From: Studio5 Architects [REDACTED]
Sent: 20 October 2015 16:51
To: David Easton
Cc: Robin Mincik
Subject: 15.903 10 Mariners Quay_LU/261/15/HH amended drwg 15.903-TP01C

Further to receipt of your recent comments on the submitted drawings for the alterations to 10 Mariners Quay, Littlehampton (ref: LU/261/15/HH), please see the attached drawing 15.903-TP01C which has been amended as follows:

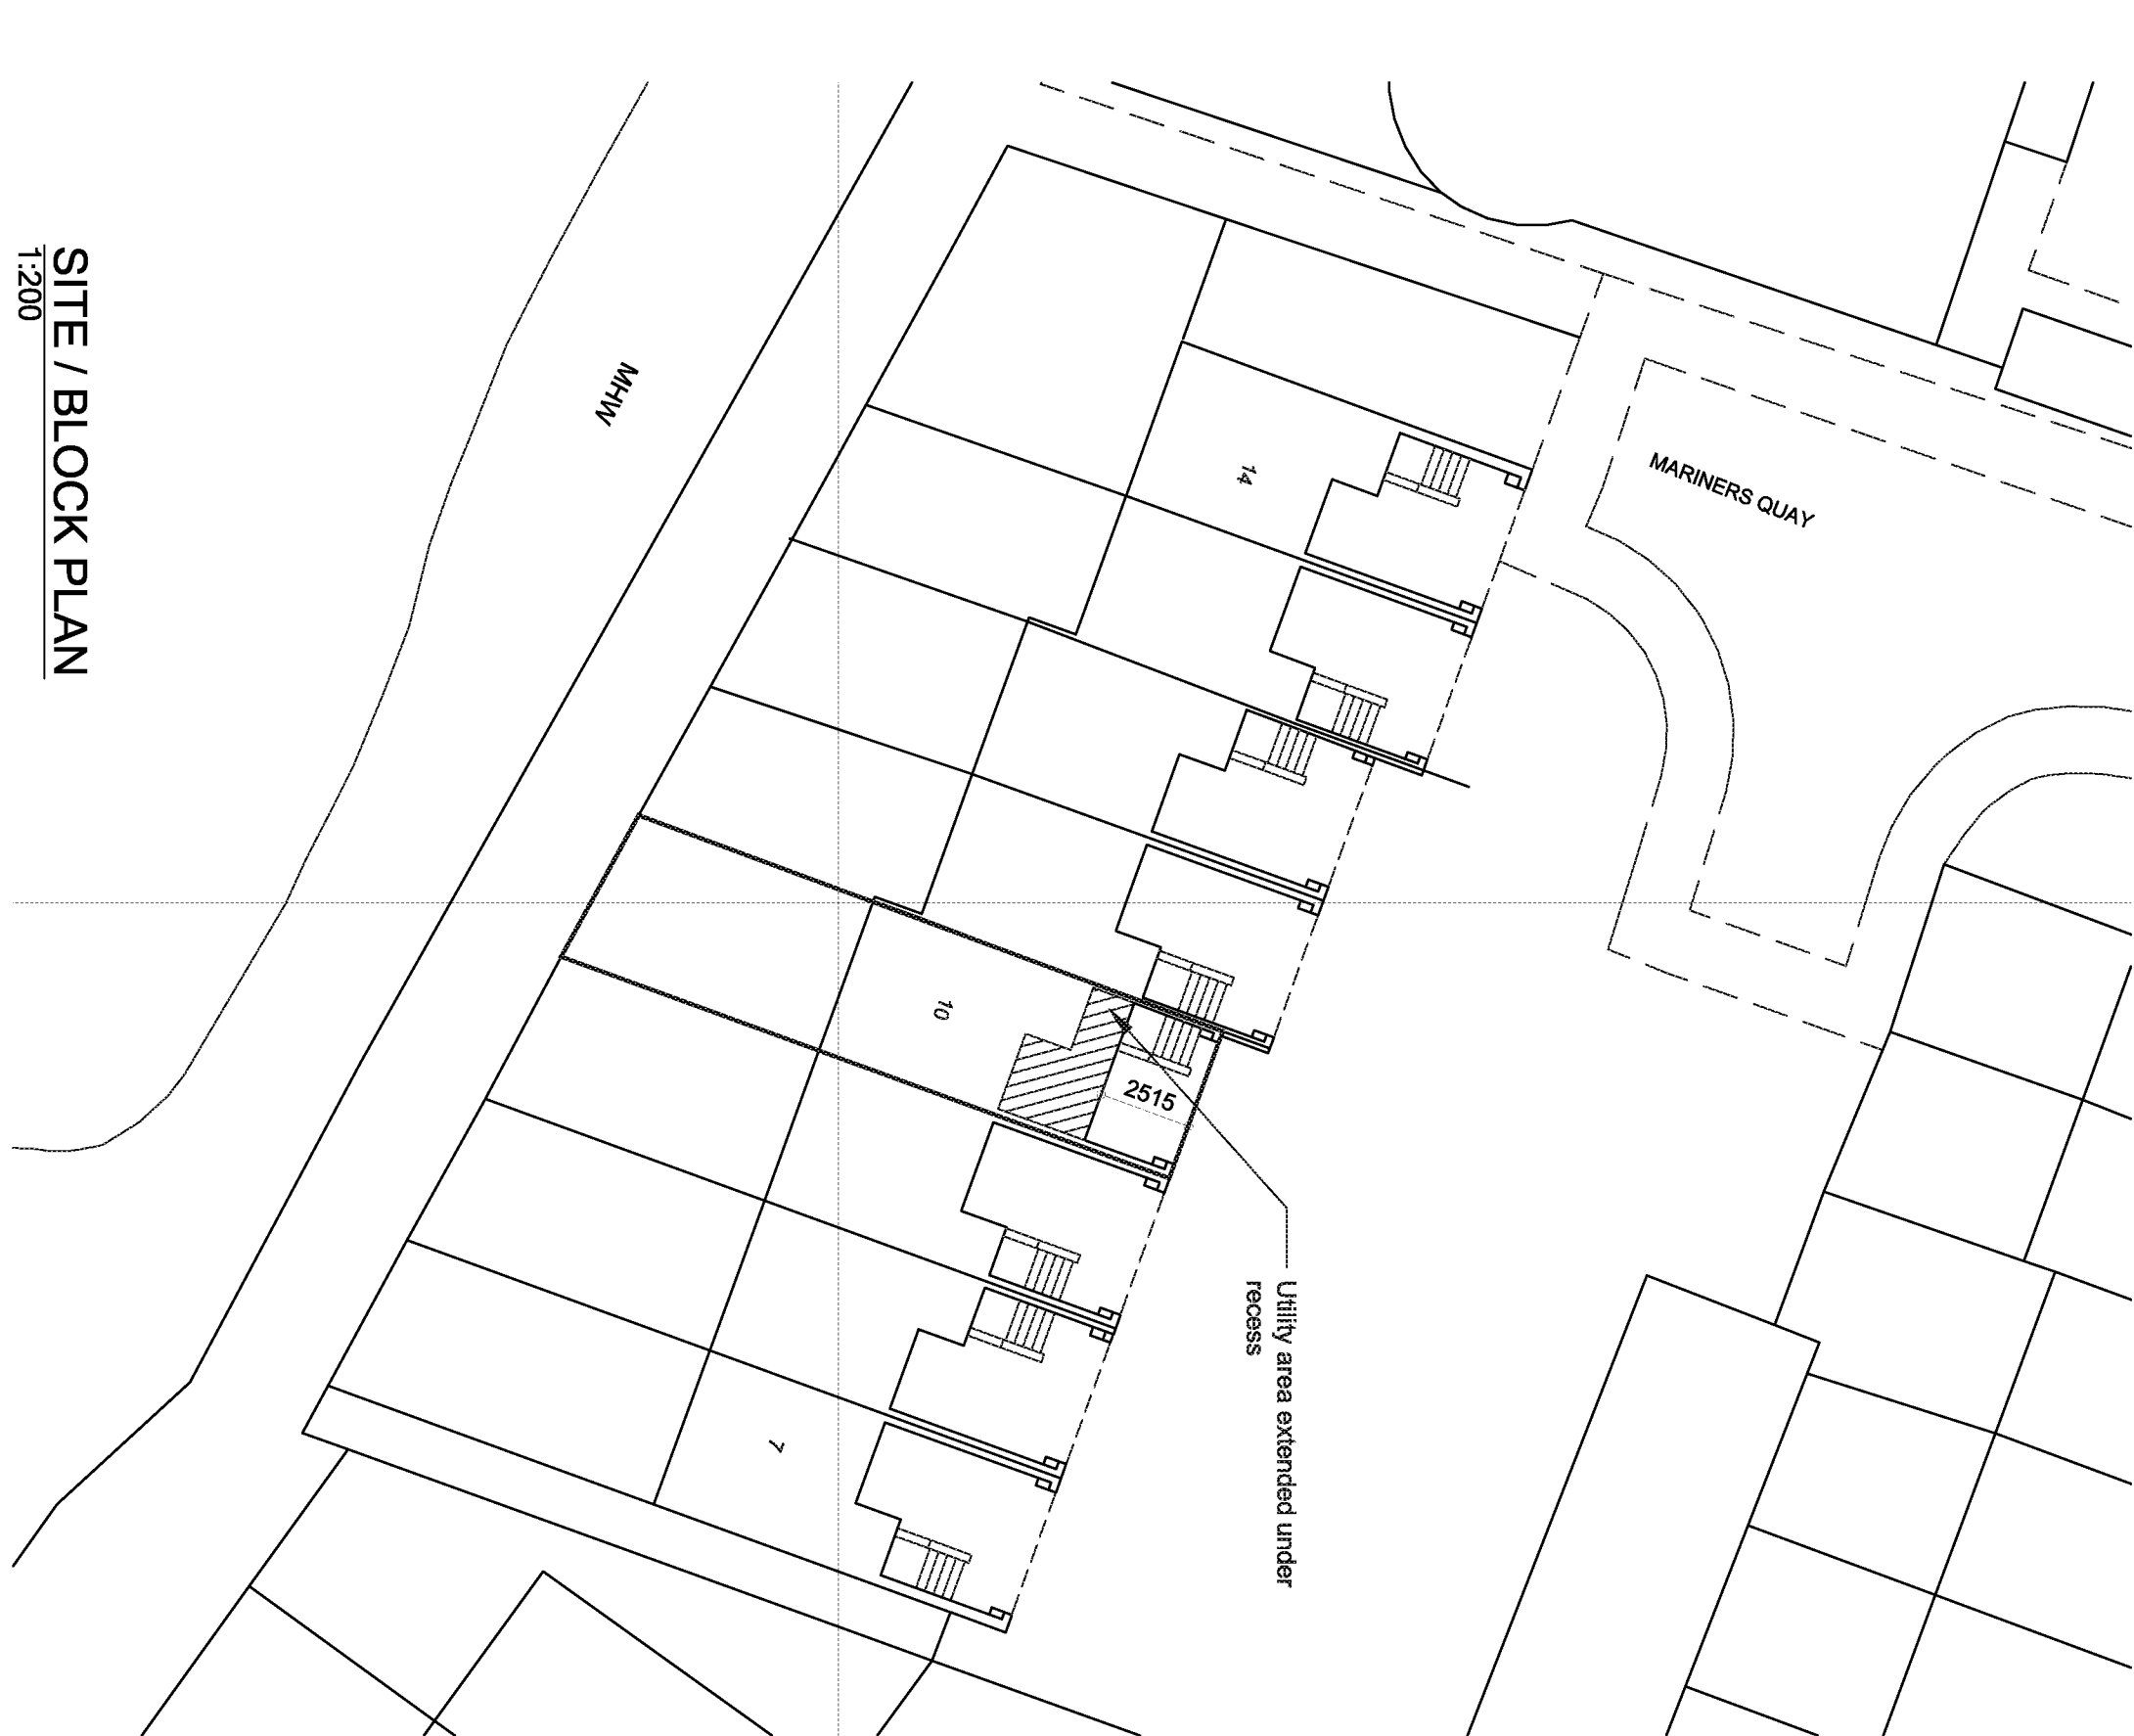
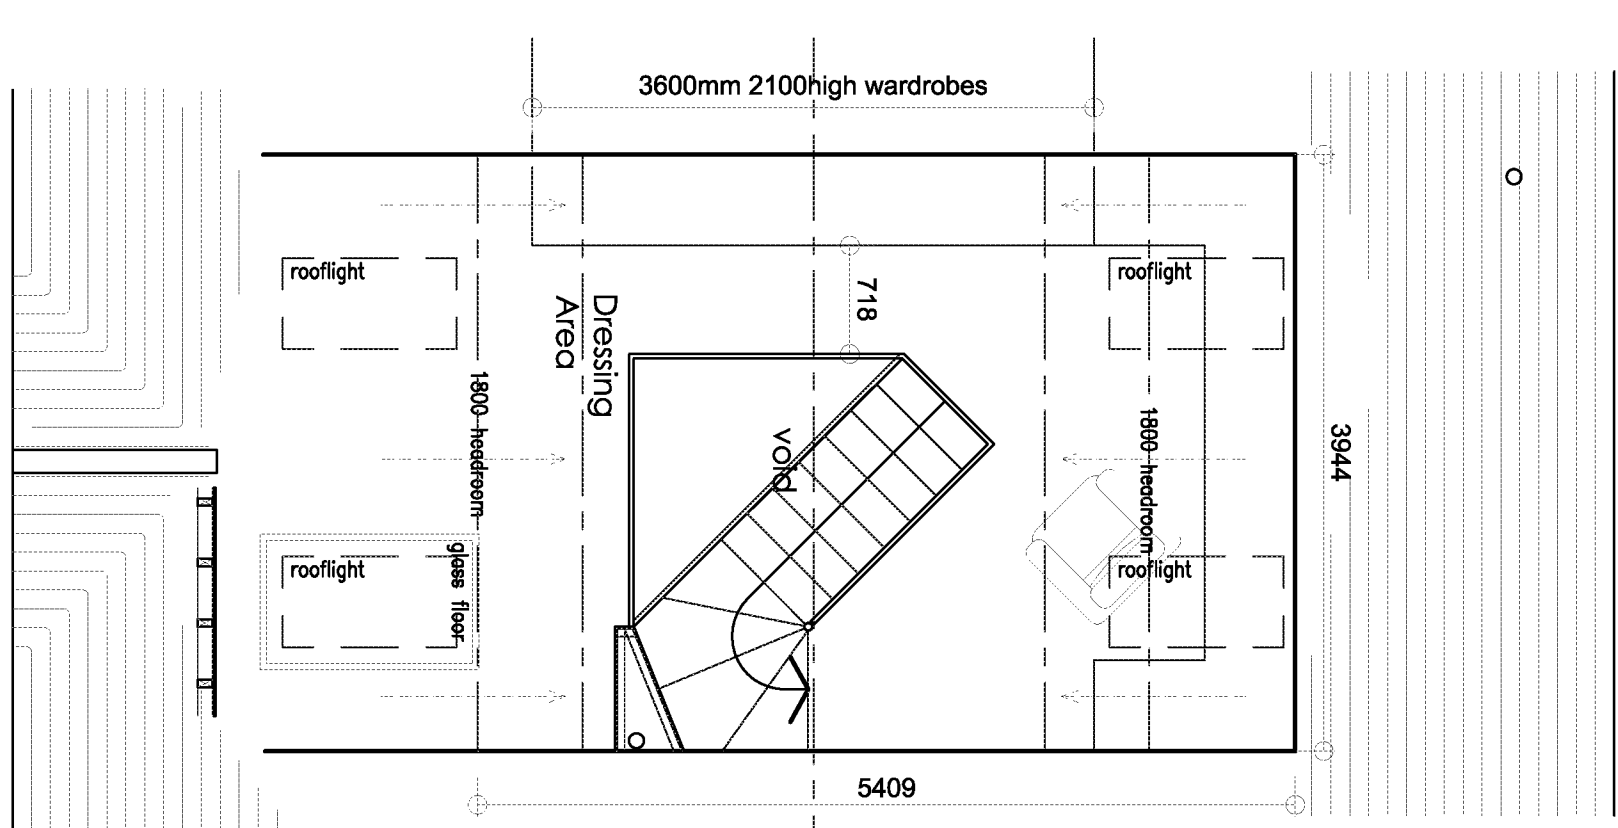
- Alterations to 2nd floor windows omitted
- Introduction of Juliette balcony omitted
- Extension of ground floor decking and handrails omitted
- Bathroom layout amended
- Utility window amended
